NSW RURAL FIRE SERVICE

Your reference: MP 08_00167 (Mod 2)

12 April 2017

MP 08_0167 (Mod 2) – Belle O'Connor Street, South West Rocks

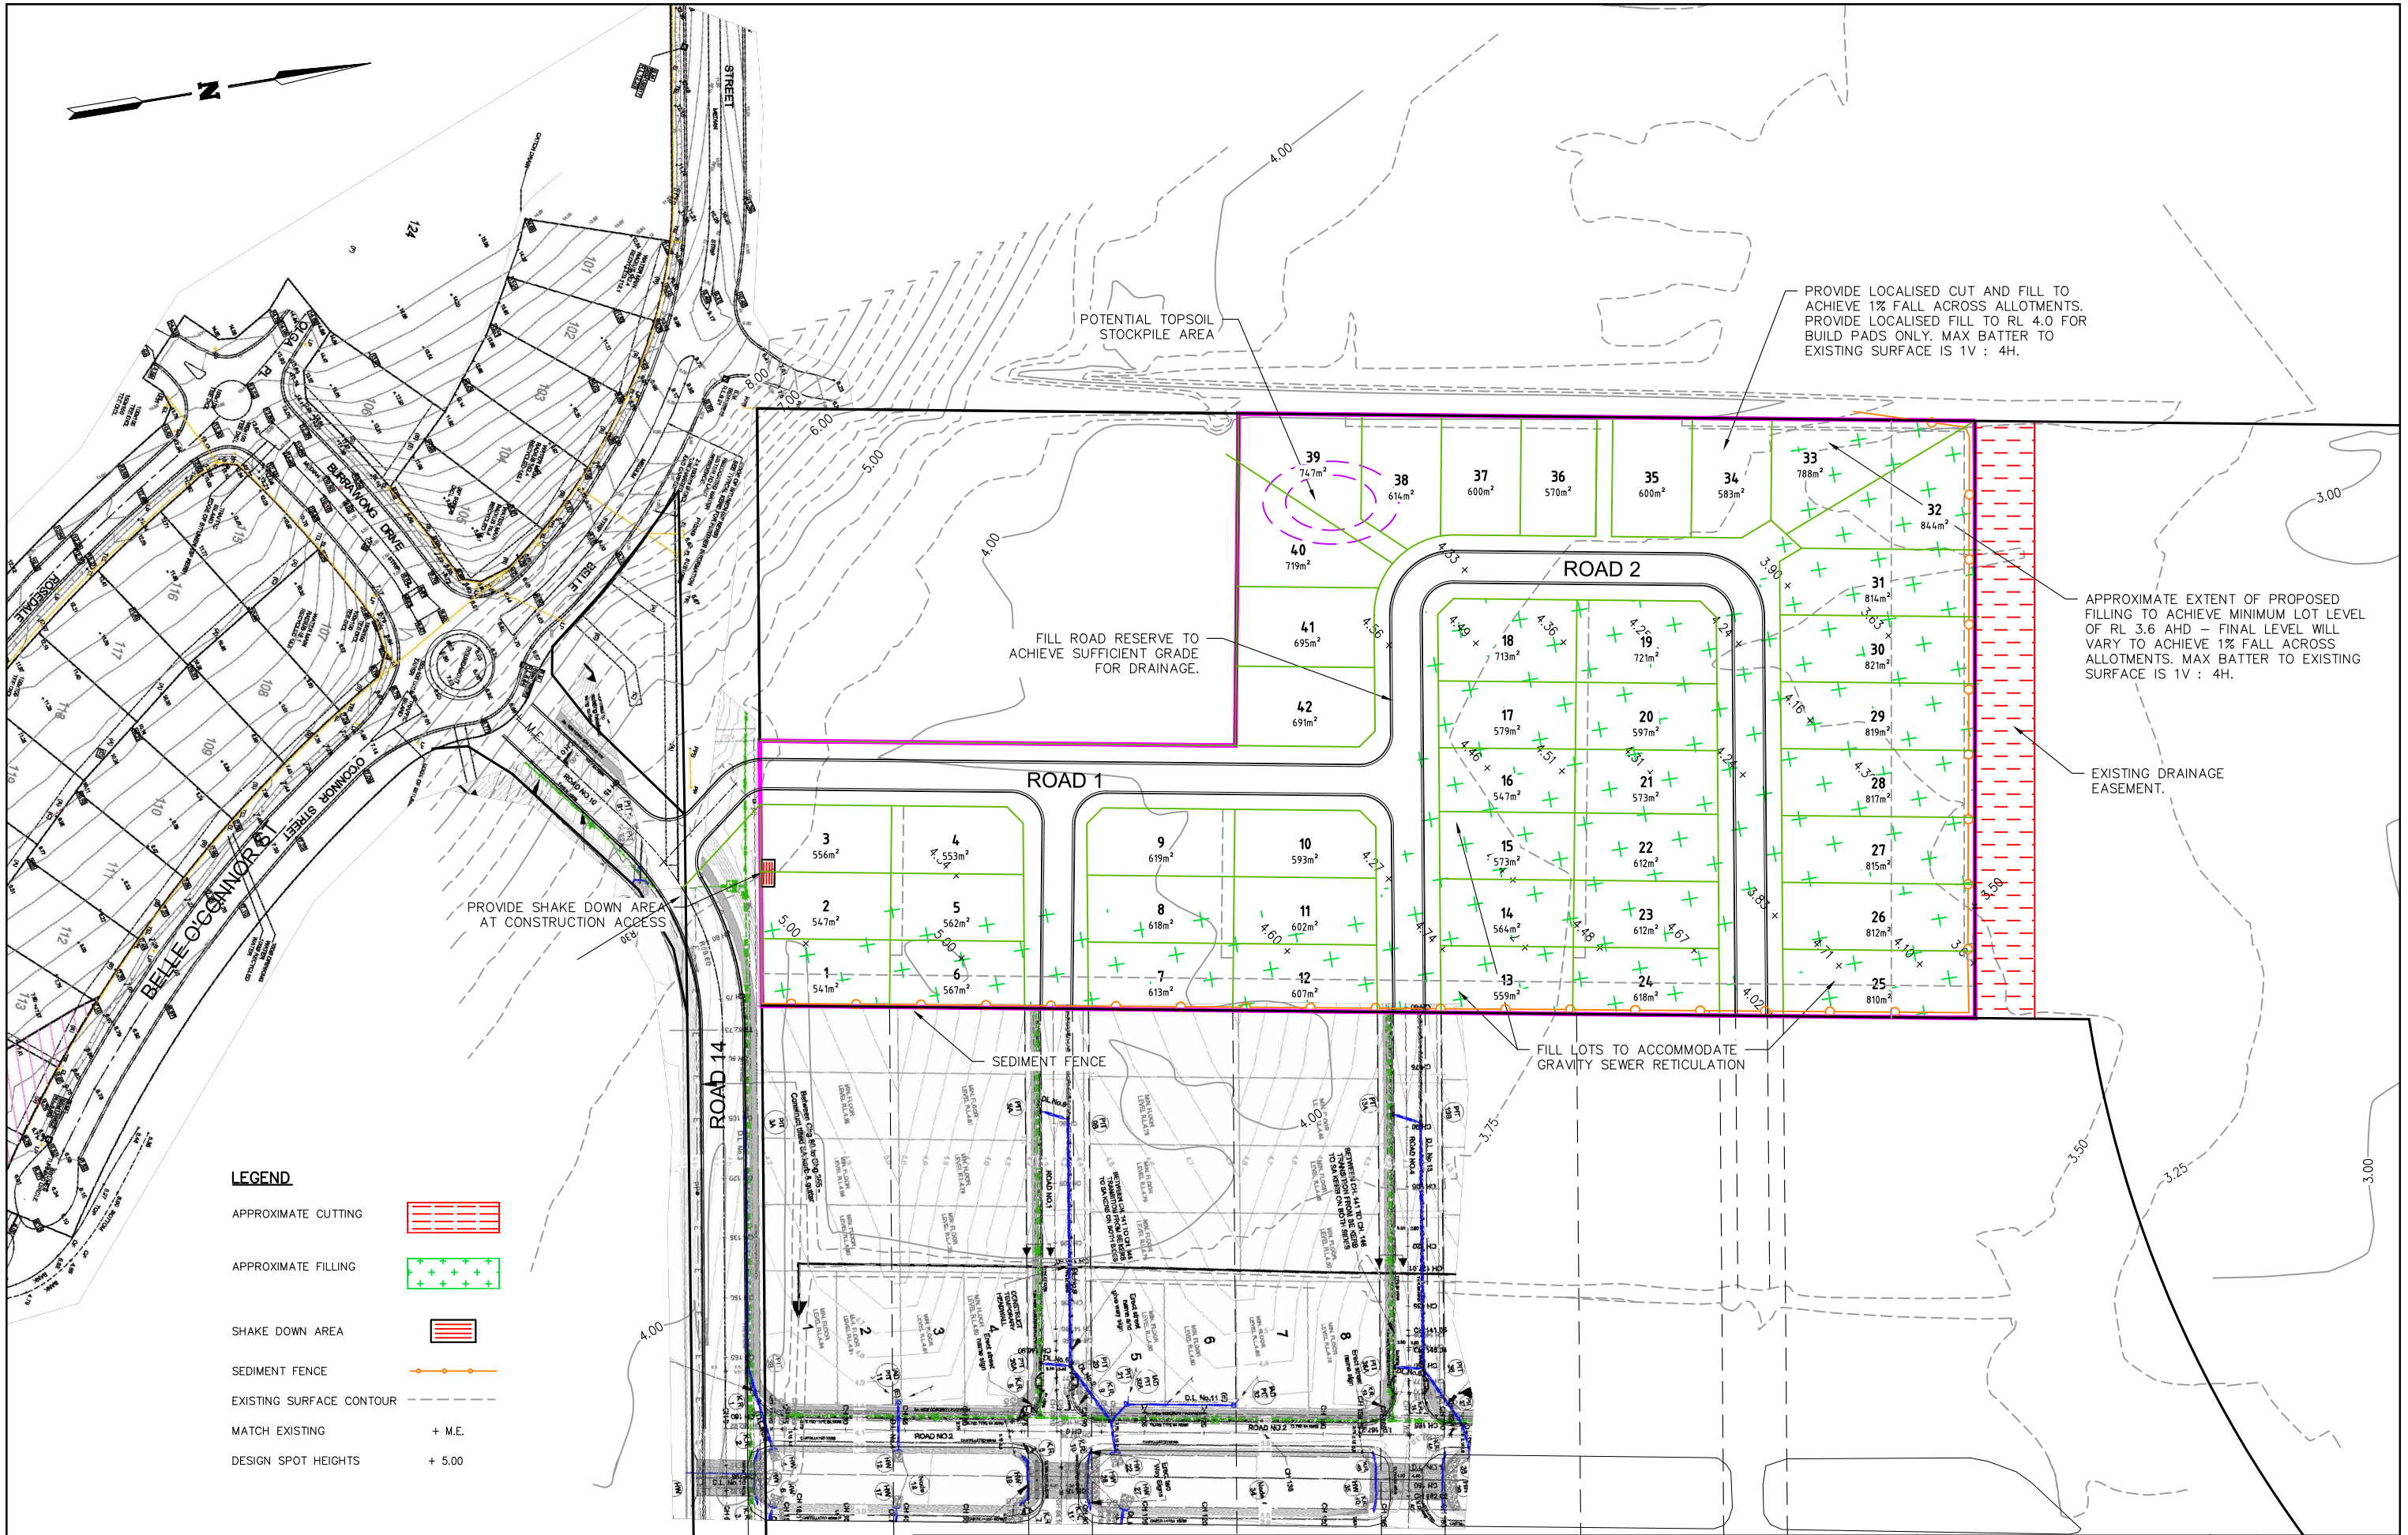
It is recommended that the proposed condition be amended to reference the following plan:

Design Drawings prepared by deGroot and Benson, Consulting Engineers and Planners titled 'General Arrangement & Lot Layout Plan', DWG No. L36-MOD02 (DA1), 8 February 2017.
